Loft conversion including rear dormer, changes to external materials & Juliette balcony to front elevation.

32 Manor Road East Preston

Thank you for your internet representation made on 26th July 2017 which has been recorded as '**an objection**' with the comments as follows:

Elevations (scale 1:100)

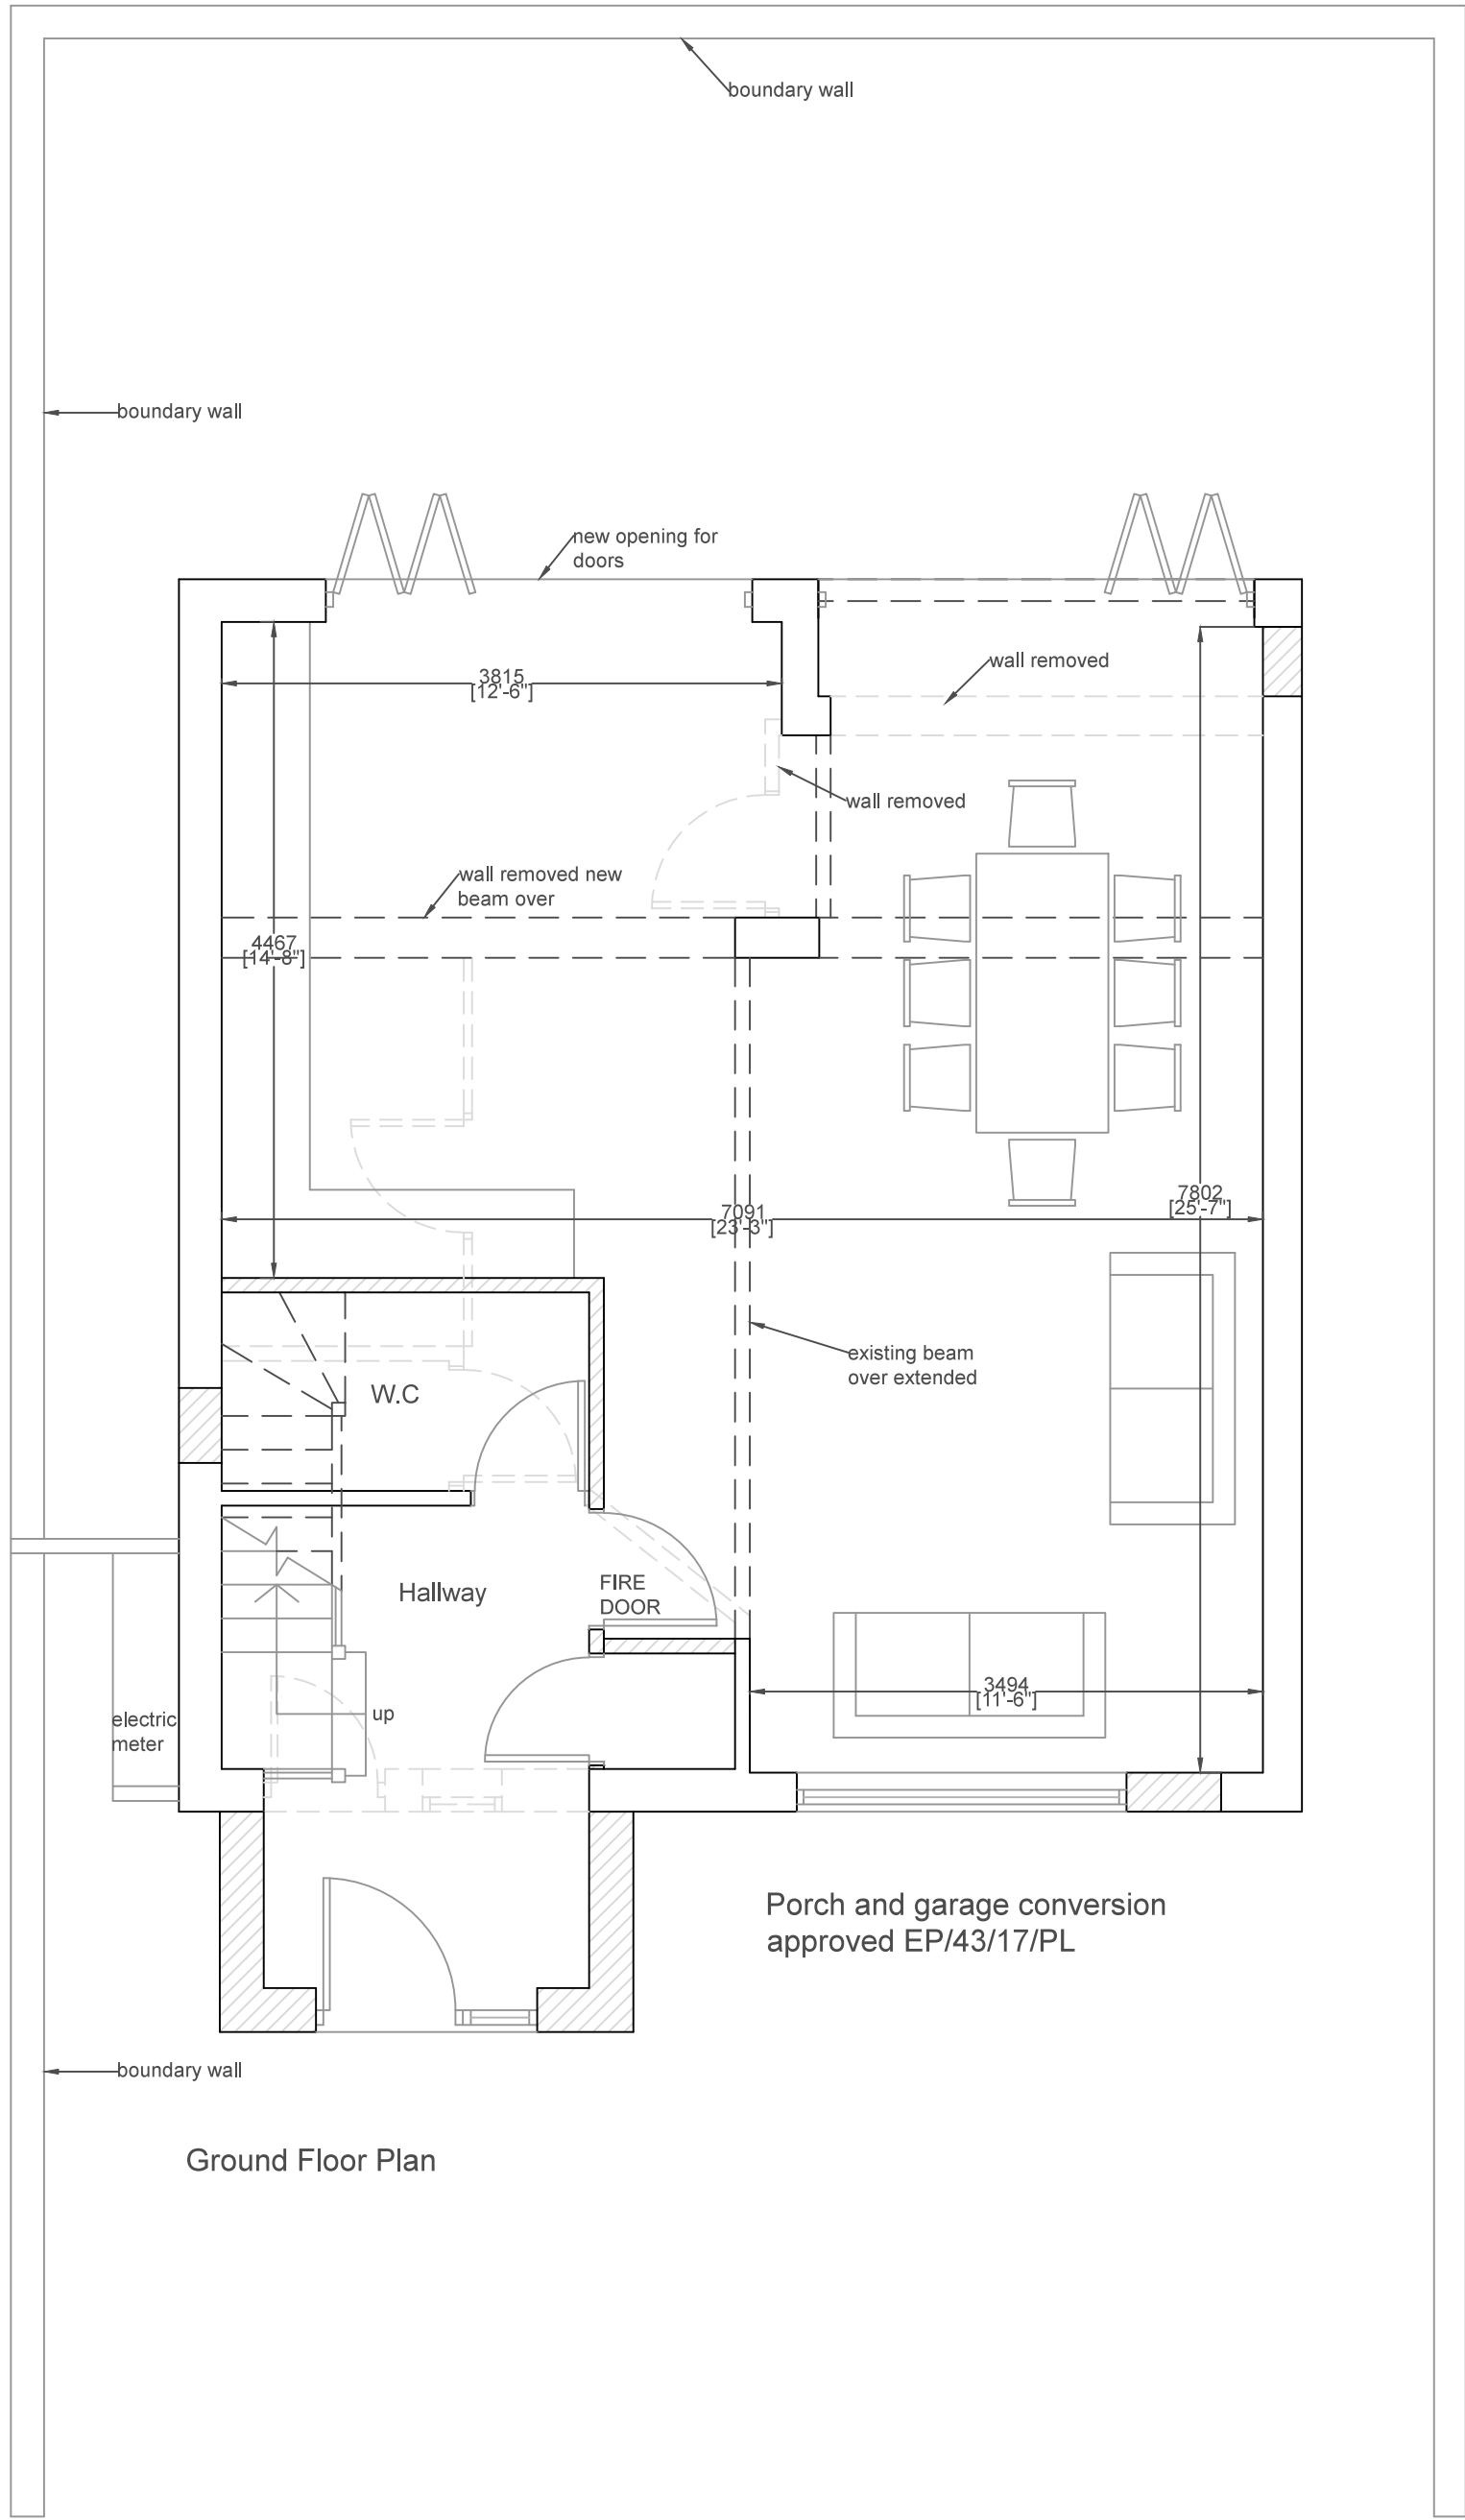
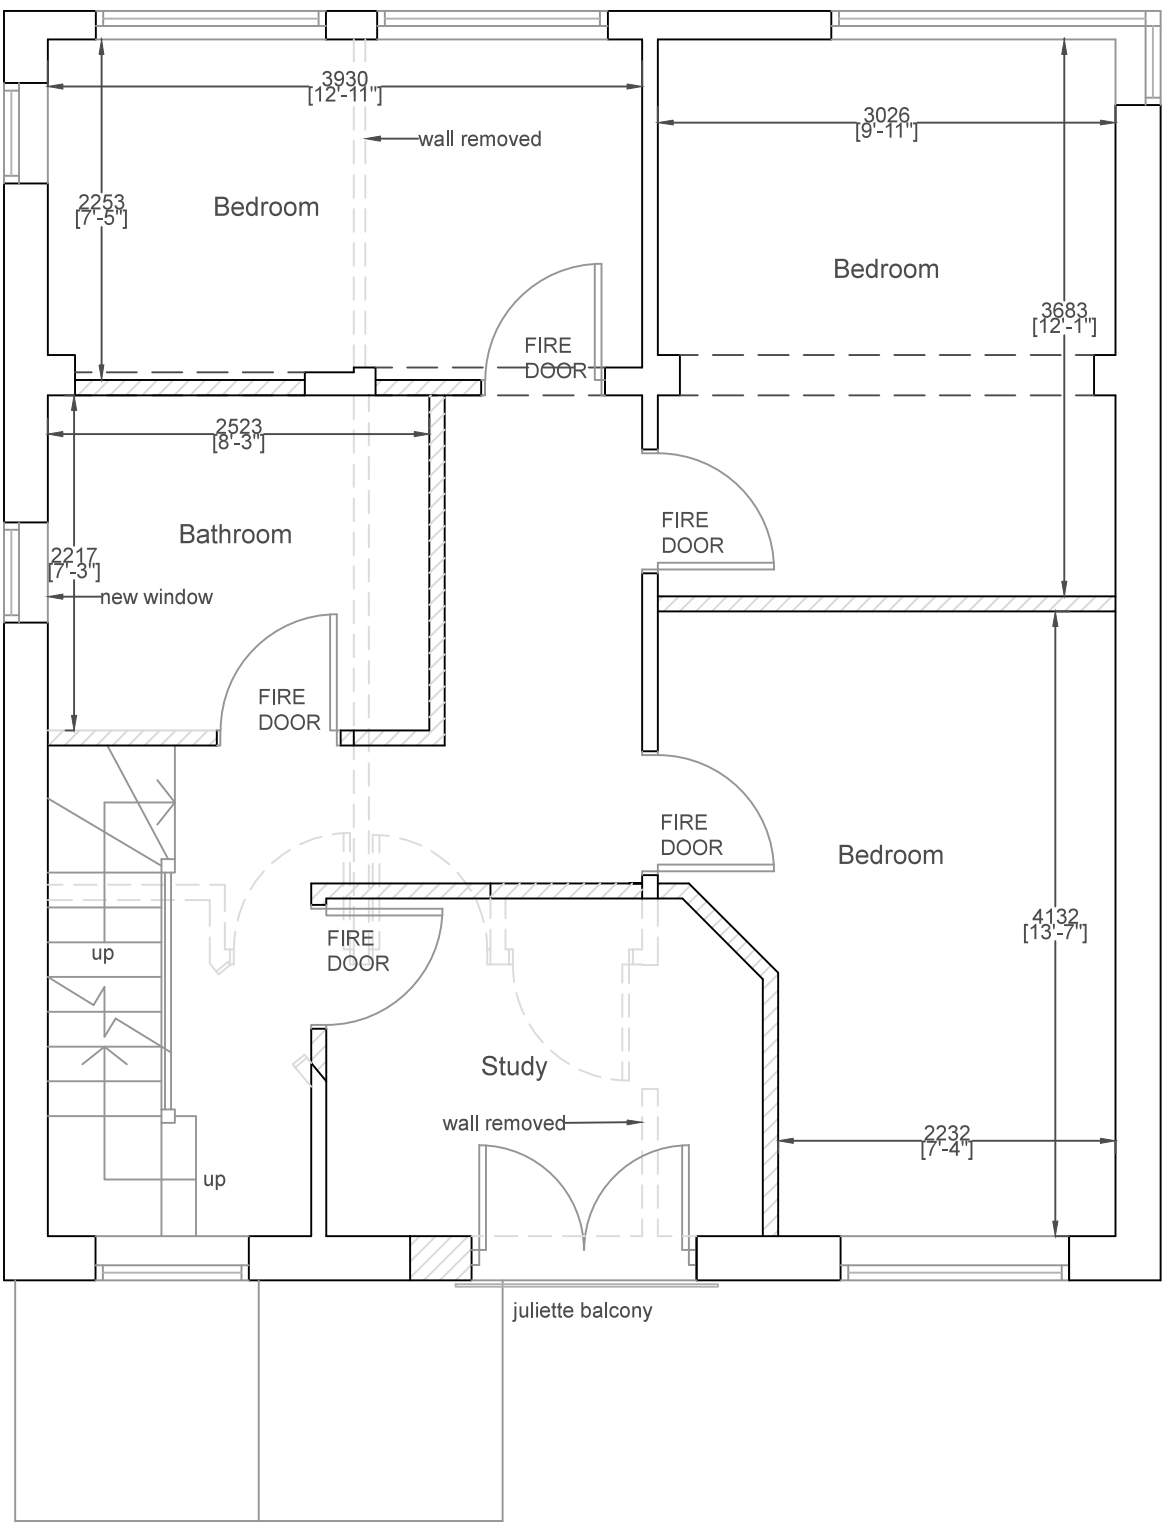
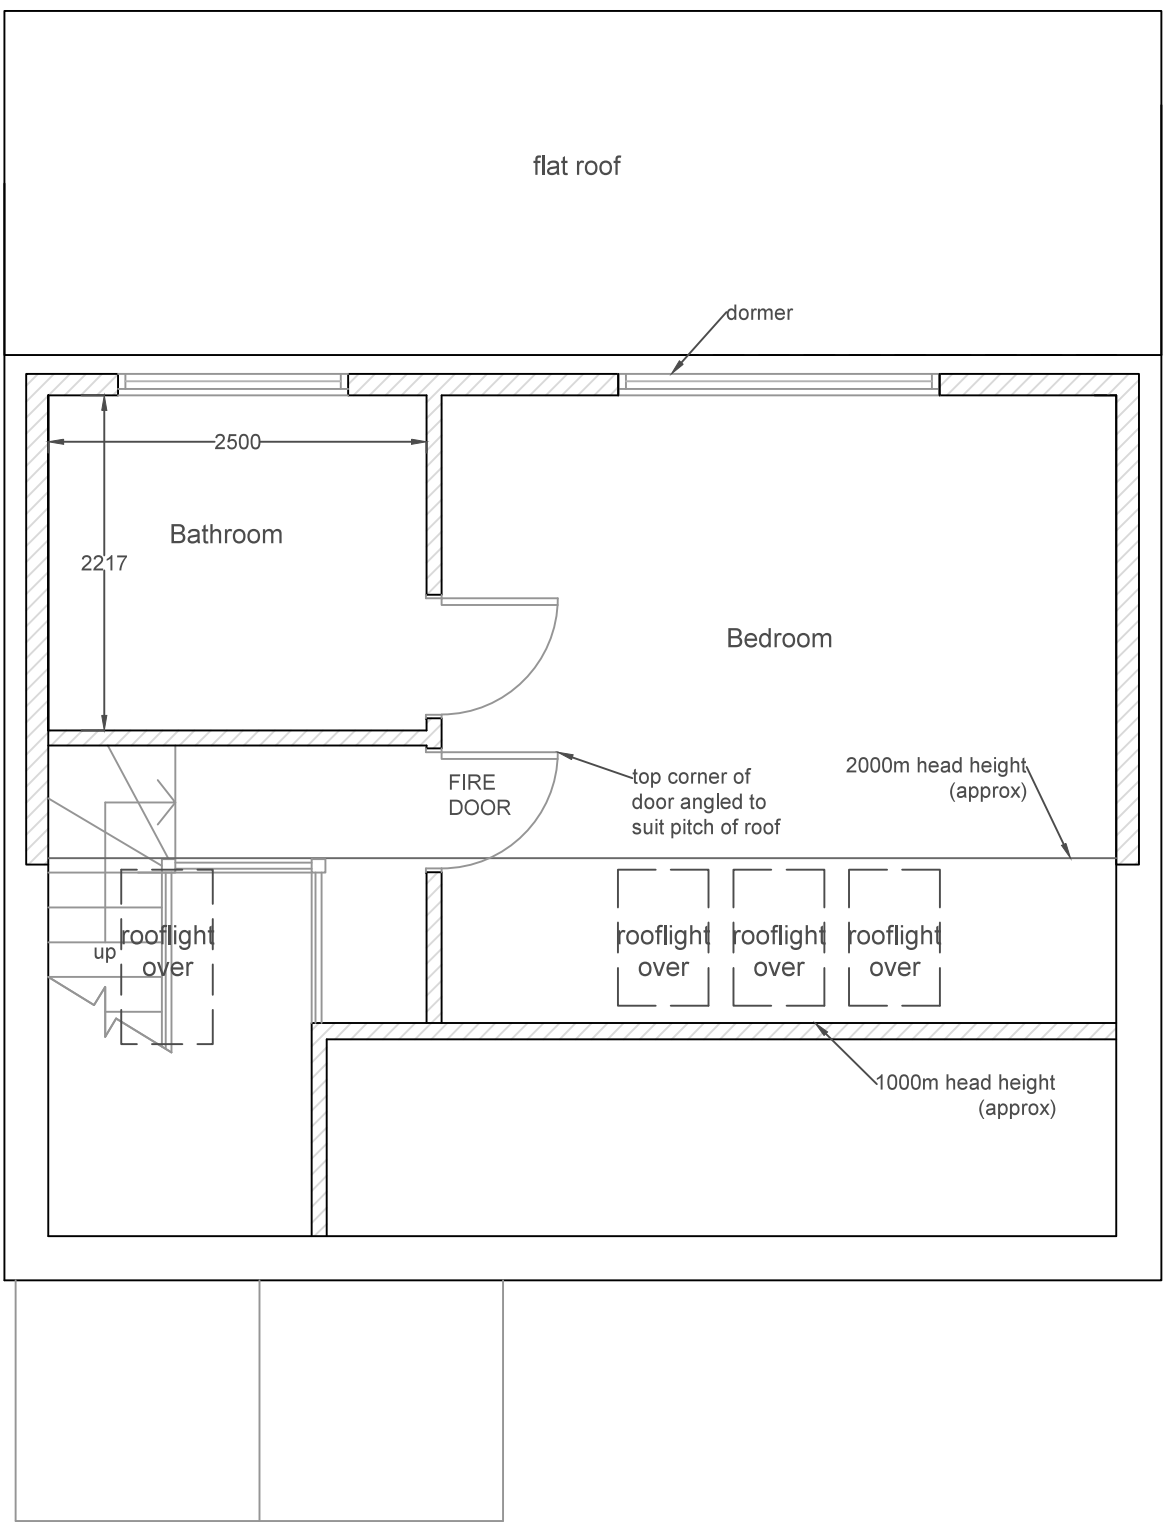
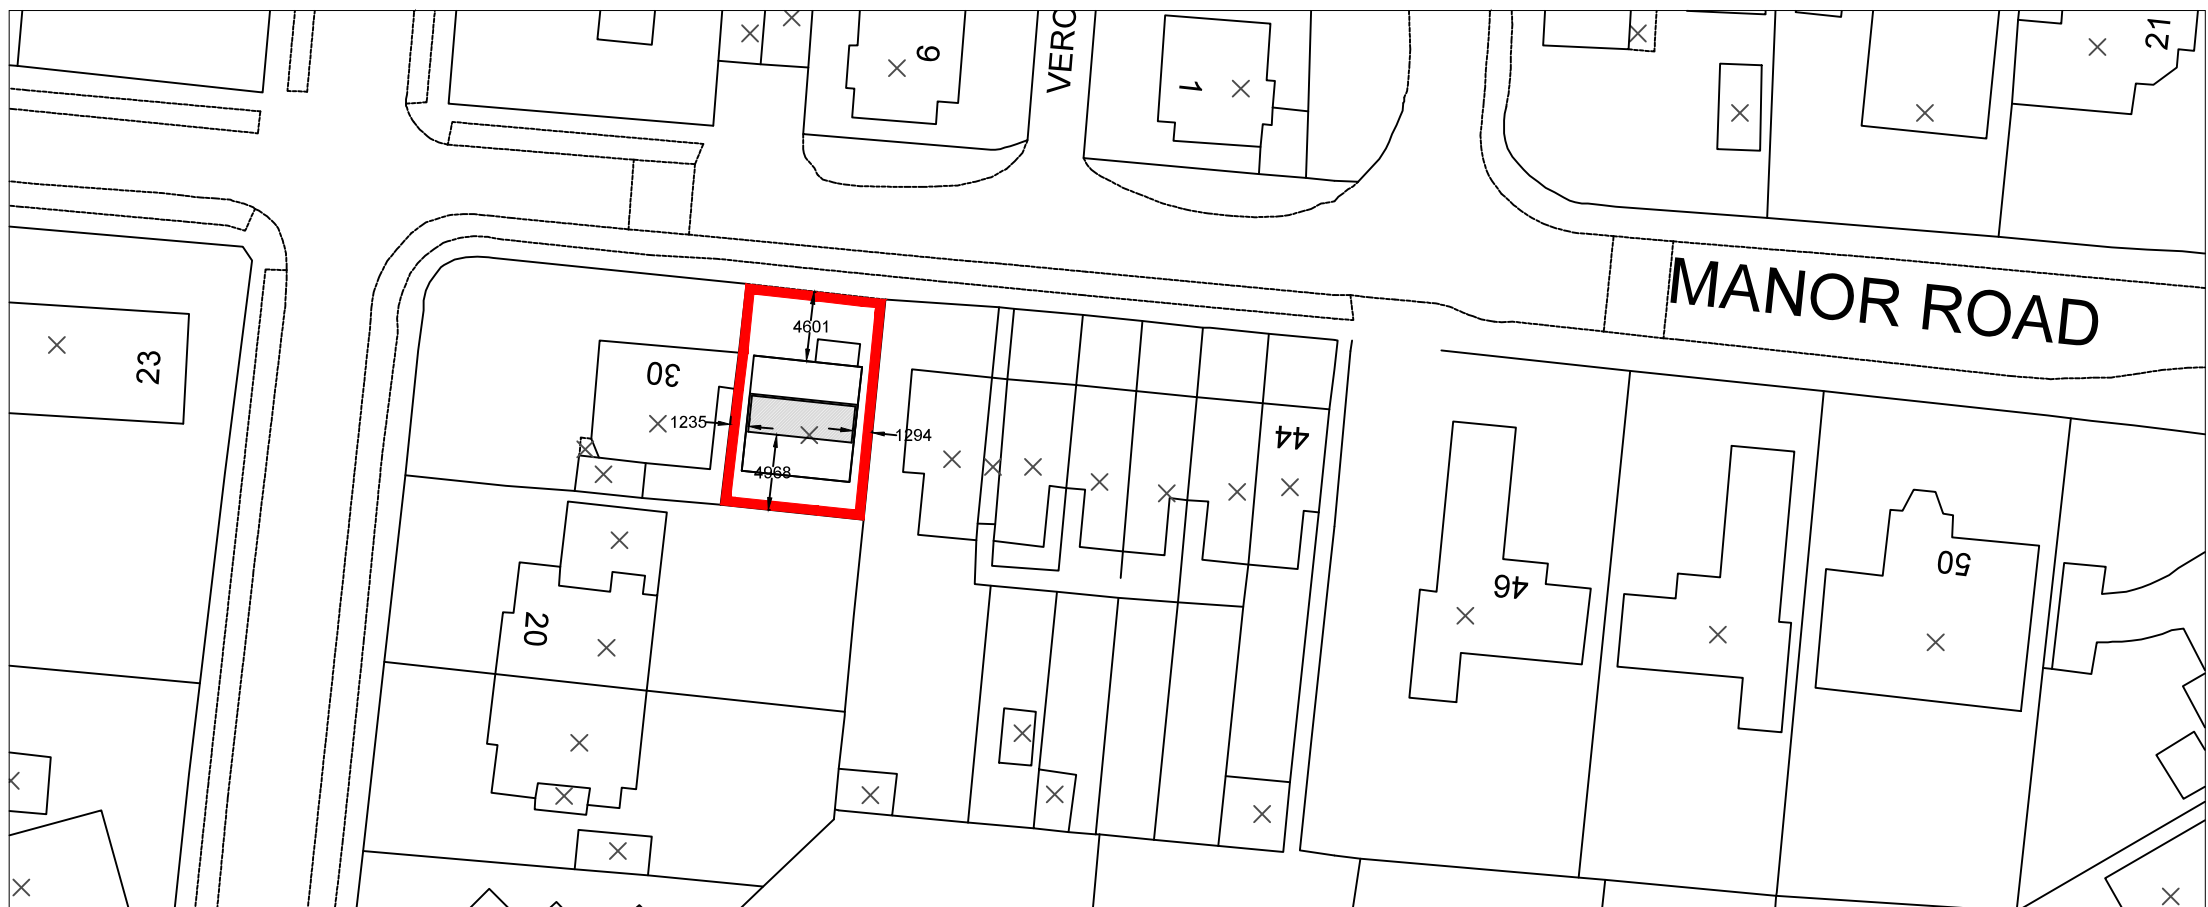
The Society does not object to the addition of a dormer and balcony to the house, but it does object to the proposed materials. Greater clarity about the proposed materials is also required.

The use of Cedral cladding on the eastern gable is inappropriate - the material is not used on any adjoining house. The proposed roofing material is described as slate effect tiles but the colour is not specified. The windows are t.b.c.

In order to conform to Policy 1 of the East Preston Neighbourhood Plan, the use of Cedral cladding should be avoided. The roofing tiles harmonise in colour and texture with those of adjoining houses. The windows should be light in colour to harmonise with the neighbours.
